Engineers Comments Regarding Surface Water Drainage

Application Reference:	CM/29/25/HH	Reviewer Reference:	ADC/KW/PC
Planning Officer:	Silvie Steiningerova	Date of Review:	17/12/25
Site Name:	2 Rose Cottages, Climping Street, BN17 5RH		
Application Description:	Part single, part two storey side and single storey rear extensions and creation of a drive, following demolition of existing extensions.		
Assessment Number:	1 of 1

Drainage Strategy & Lidsey Drainage Statement, D2358/DS1.1

## BOREHOLE LOG

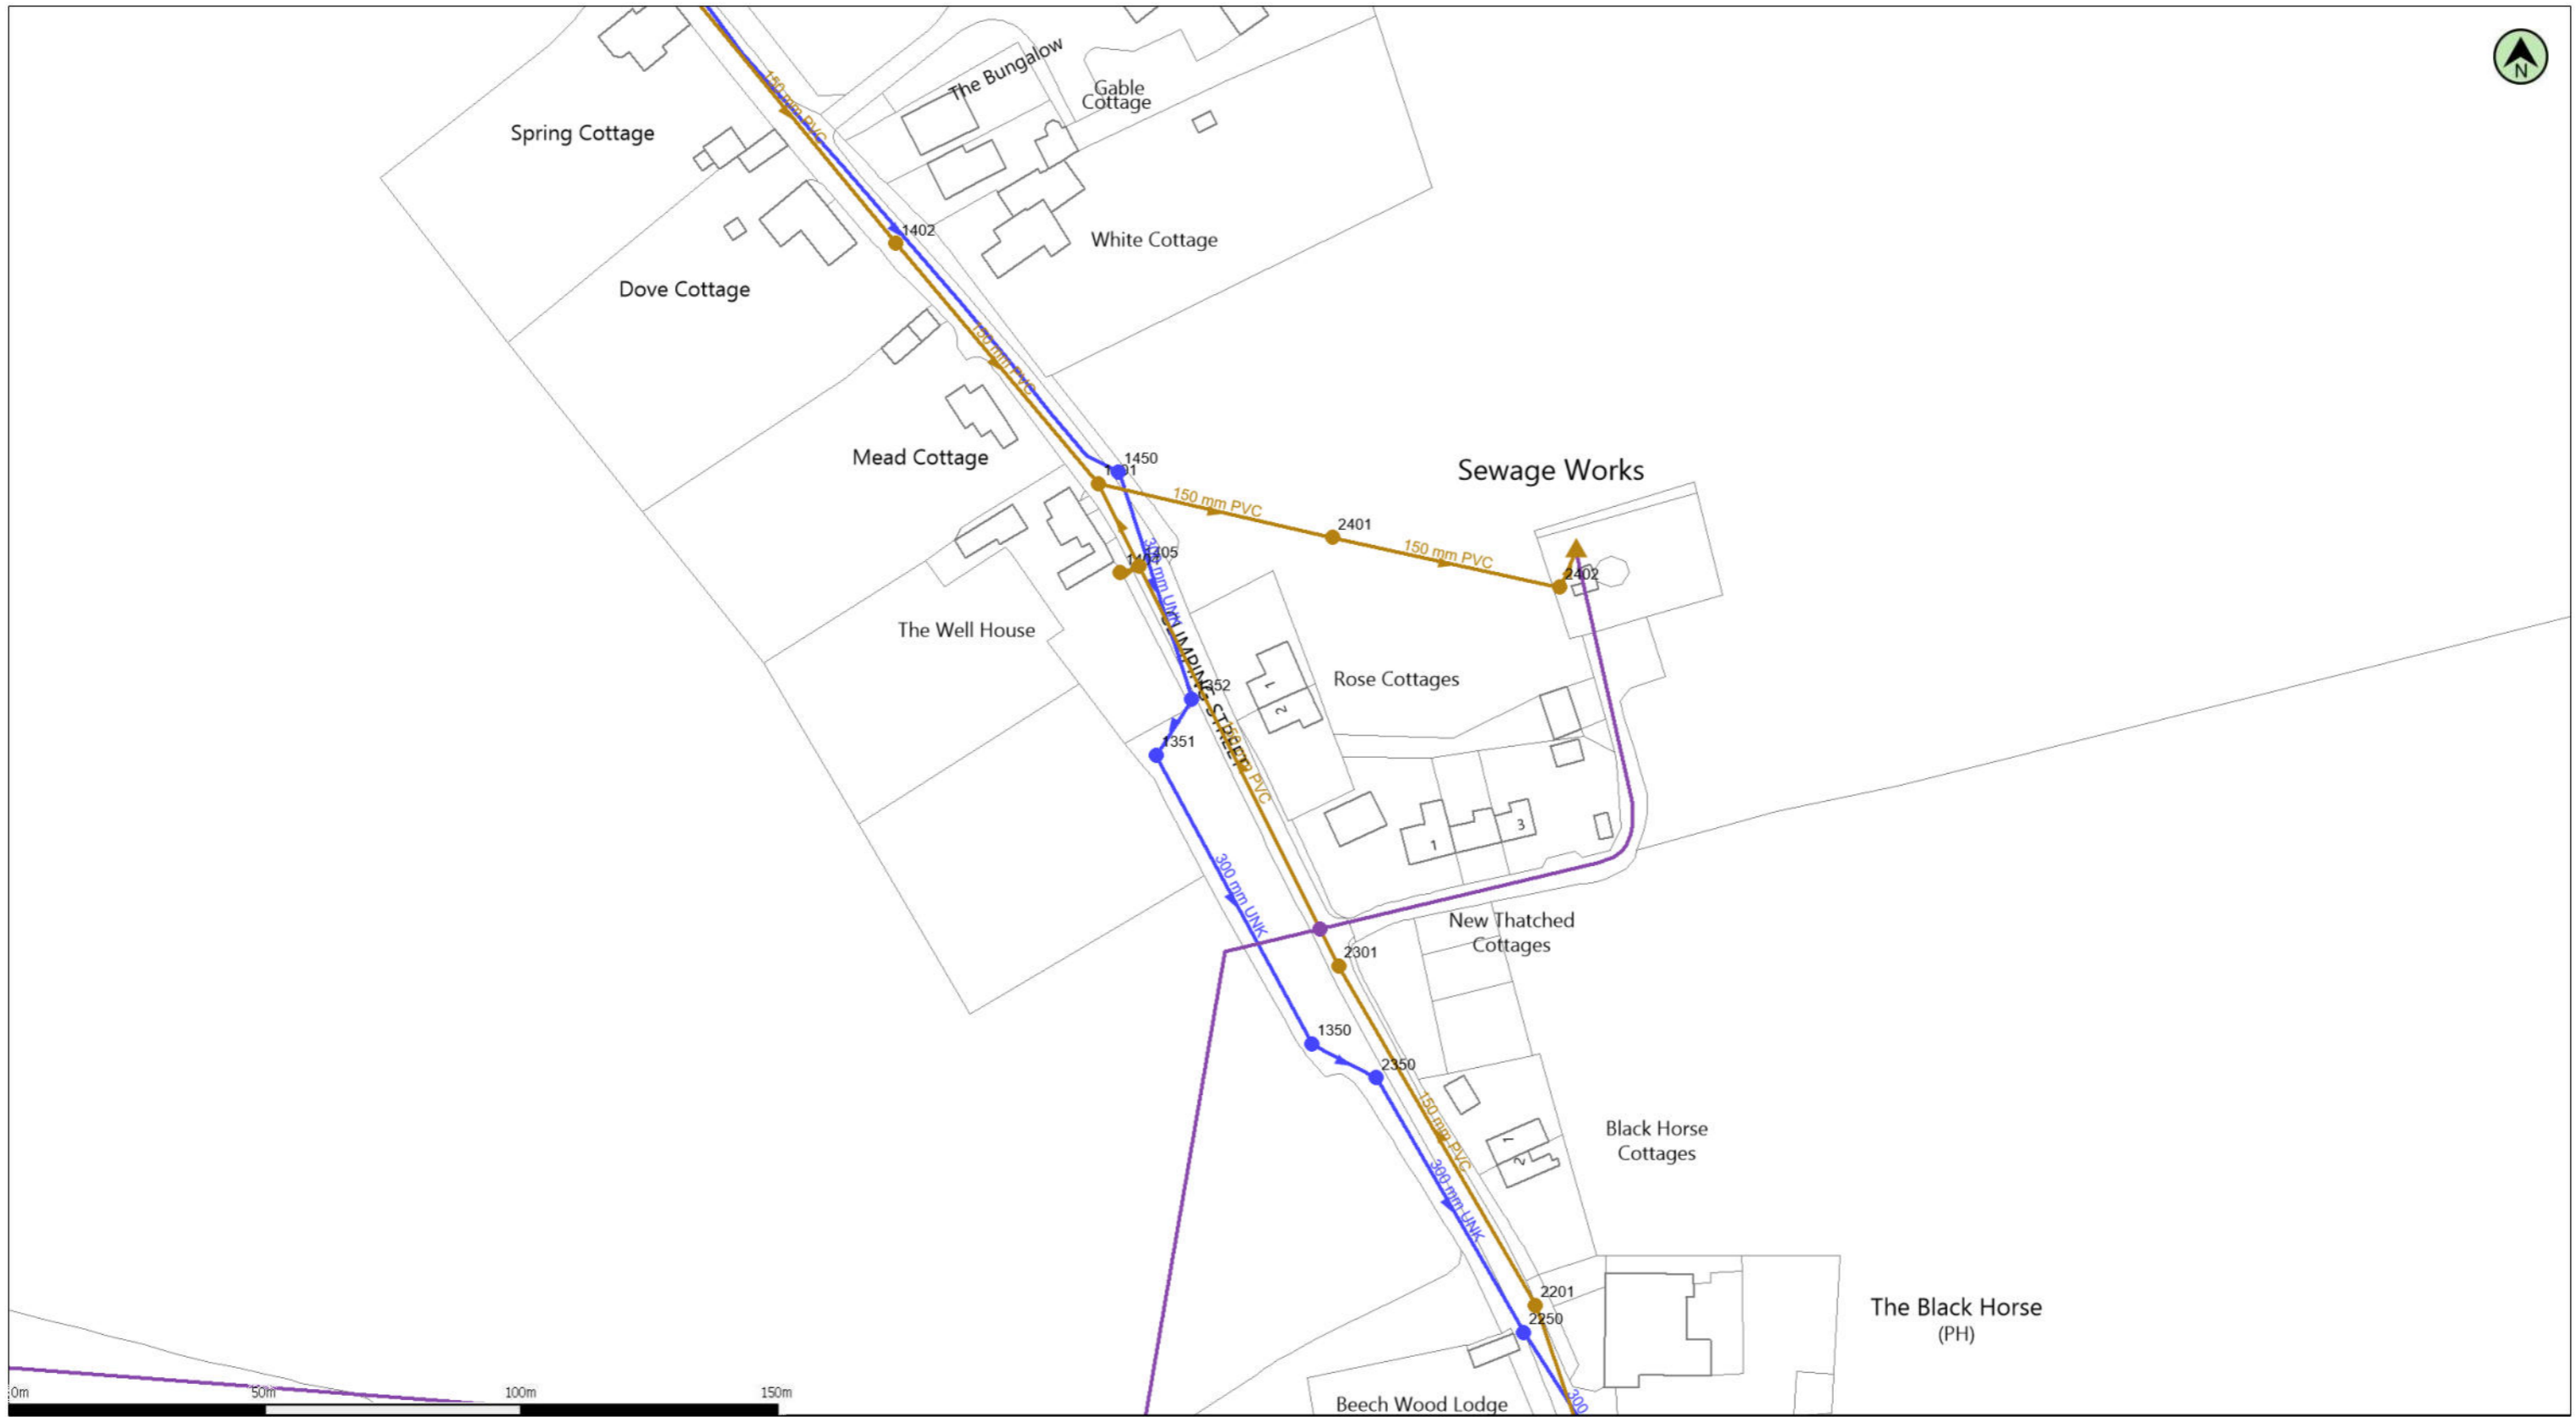
- 1.3. A historic borehole log (dated August 1982) has been provided, indicating that no groundwater was encountered to a depth of 4 m below ground level (bgl). While this information may offer some general background on the site's groundwater conditions and soil profile, it does not, in isolation, constitute reliable evidence and should not be used to inform the proposed design. The borehole log does not identify the location of the borehole, provides no details of the monitoring period, and appears to reflect observations from a single site visit undertaken during the summer months only.

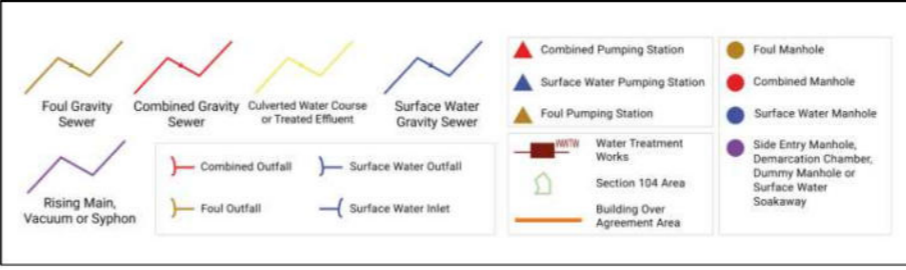
- 1.6. There is a public surface water sewer located to grass verge in the opposite side of the highway within the highway. No information regarding this option has been submitted. If infiltration is not viable, the applicant would need to investigate the possibility of connecting surface water to the sewer at the front of the site, via Southern Water.
